**Application Reference:** 2025/0057

**Site Address:** 19 Wilthorpe Road, Redbrook, Barnsley, S75 1JB

**Description:** Replacement of existing boundary wall at front of property, with a combination of brick wall and fencing to a maximum height of 1.5 metre. (Approximately 1 metre of which would be solid and the upper approximately 0.5 metre would be a perforated style fencing). Extension to existing drive opening, new driveway gates and separate pedestrian gate, to tie in with the height and style of the front fencing to a maximum height of 1.5 metre. Widening of existing drop kerb to accommodate new driveway gates.

PROPOSED FRONT ELEVATION
SCALE 1:50

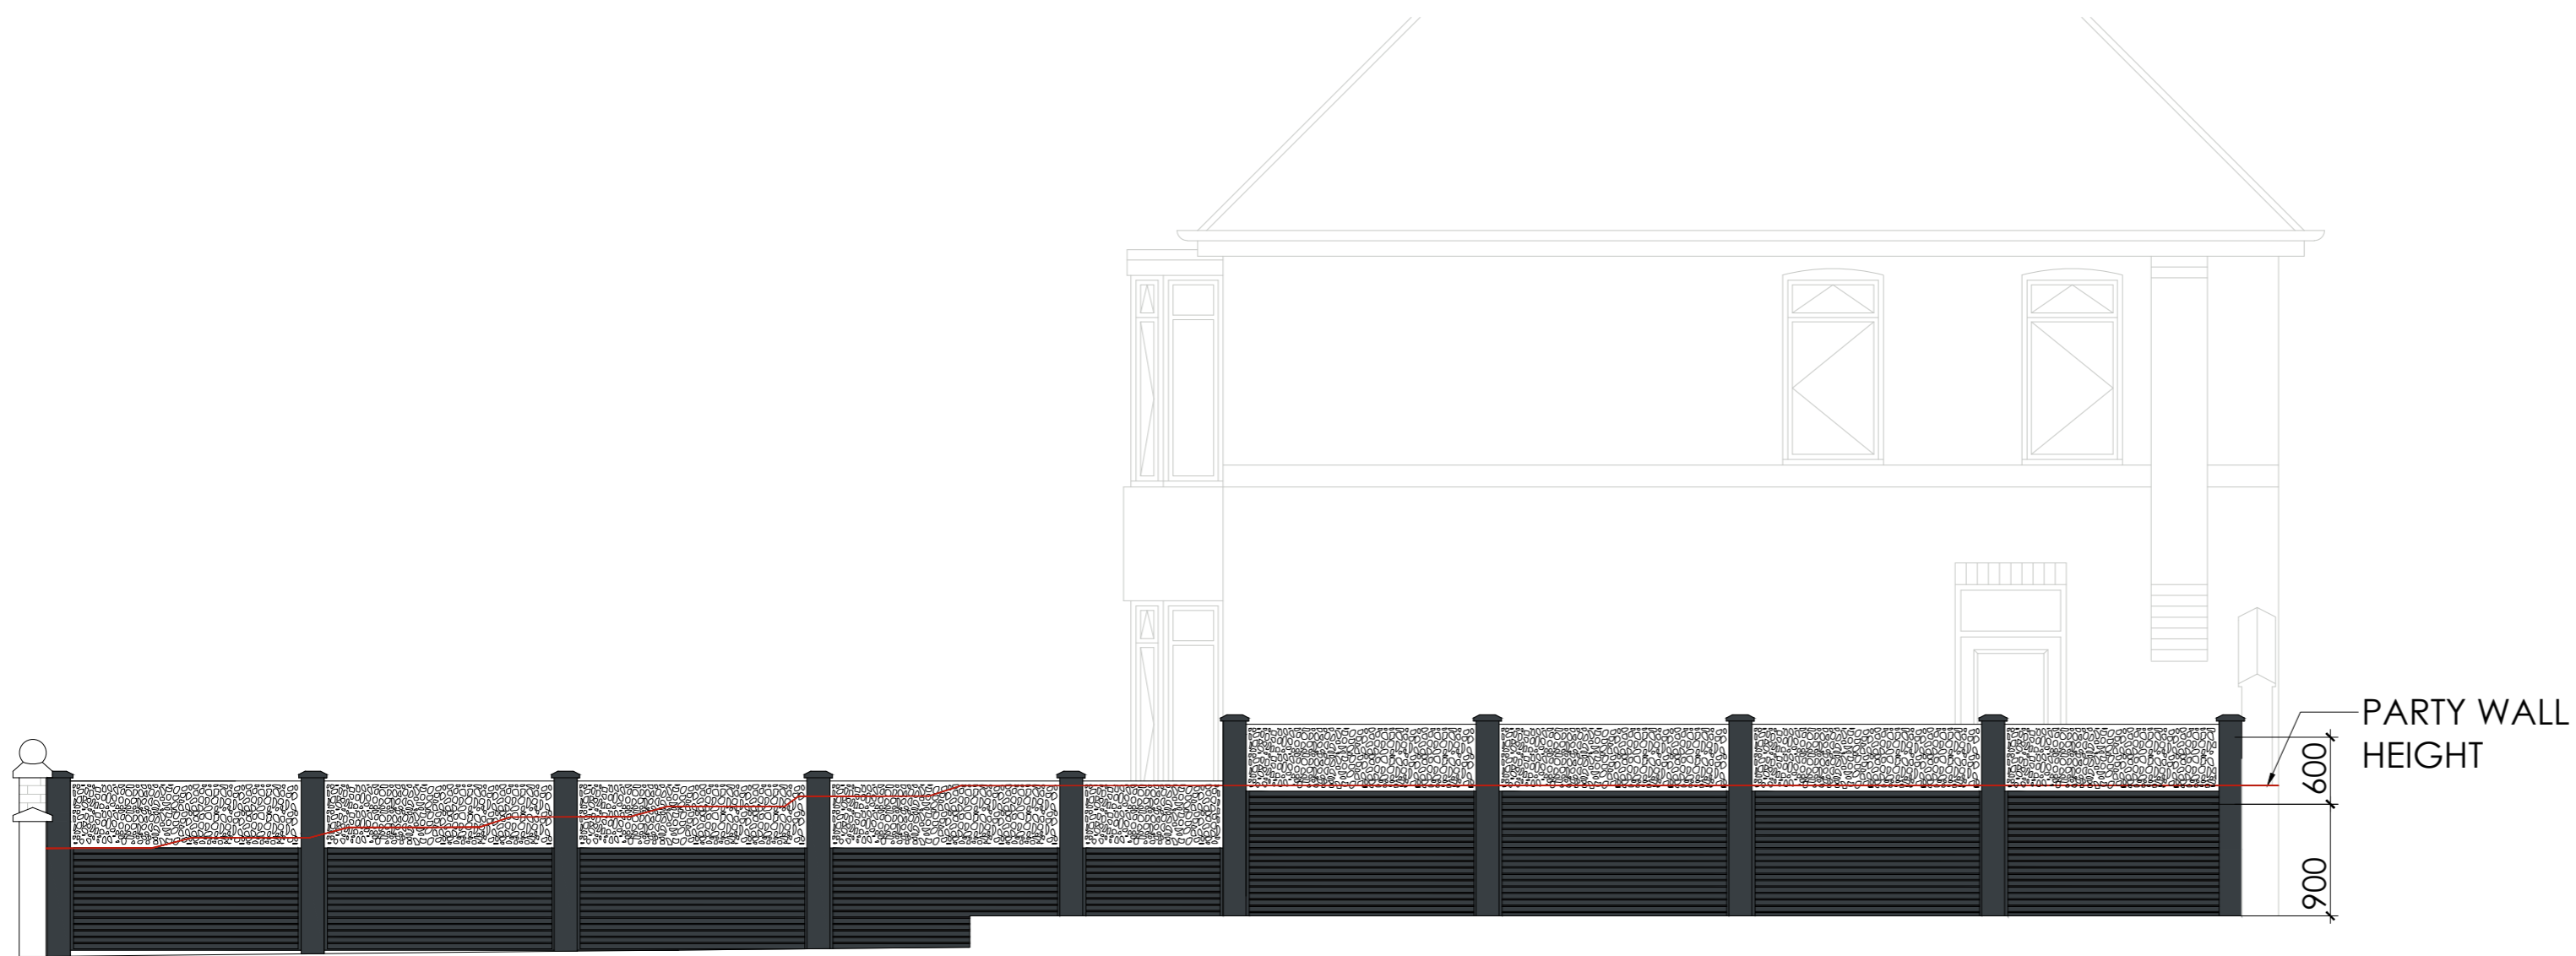
The proposed replacement boundary treatment to the front would provide an increase of approximately 0.7 metres, doubling the existing wall height. The use of brickwork to the lower 0.8 metres of the front elevation is welcomed and would be the most in keeping element of the proposal with the street scene. The proposed ‘Pebble’ style horizontal screen upper would not be in keeping with the character of the street scene. It is acknowledged the ‘Pebble’ upper is partially transparent which slightly reduces the impact of the proposal, however, this would not reduce the detriment of the proposal to acceptable levels. The use of Charles & Ivy – Hudson Style Anthracite Grey Horizontal Fence Slats to the proposed gates are also not in keeping with the character of the area. Red brickwork is a common feature within the street scene and would be considered acceptable along with metal arched gates which are also common within the street scene and complement the character of the houses. The proposed horizontal fence slats would therefore not relate to the character of the area on a prominent street within Redbrook. It is acknowledged the occasional property on Wilthorpe Road has a front wall which marginally exceeds 1 metre in height; however, no planning permission has been sought for this increase.

Having received consultation responses from highways, it is considered that the height of the proposal to the front would significantly restrict visibility when exiting the driveway, particularly in relation to pedestrian intervisibility. It is acknowledged other boundary treatment in the street scene poses similar visibility restrictions, however landscaping and planting within privately owned curtilages cannot be controlled by the planning department. Furthermore, should an application of this scale be approved, a precedent would be set which could then be used in the future to justify other schemes occasioning similar highway safety concerns. Opportunity was provided to the applicant to make alterations to the proposal for a reduction to a 1 metre height which would be more in line with neighbouring front boundary treatment, however this opportunity was refused.

In dealing with the application referred to above, amendments were requested to reduce the height of the proposed front boundary treatment to a maximum of 1 metre in the interests of highway safety. These amendments were repudiated.
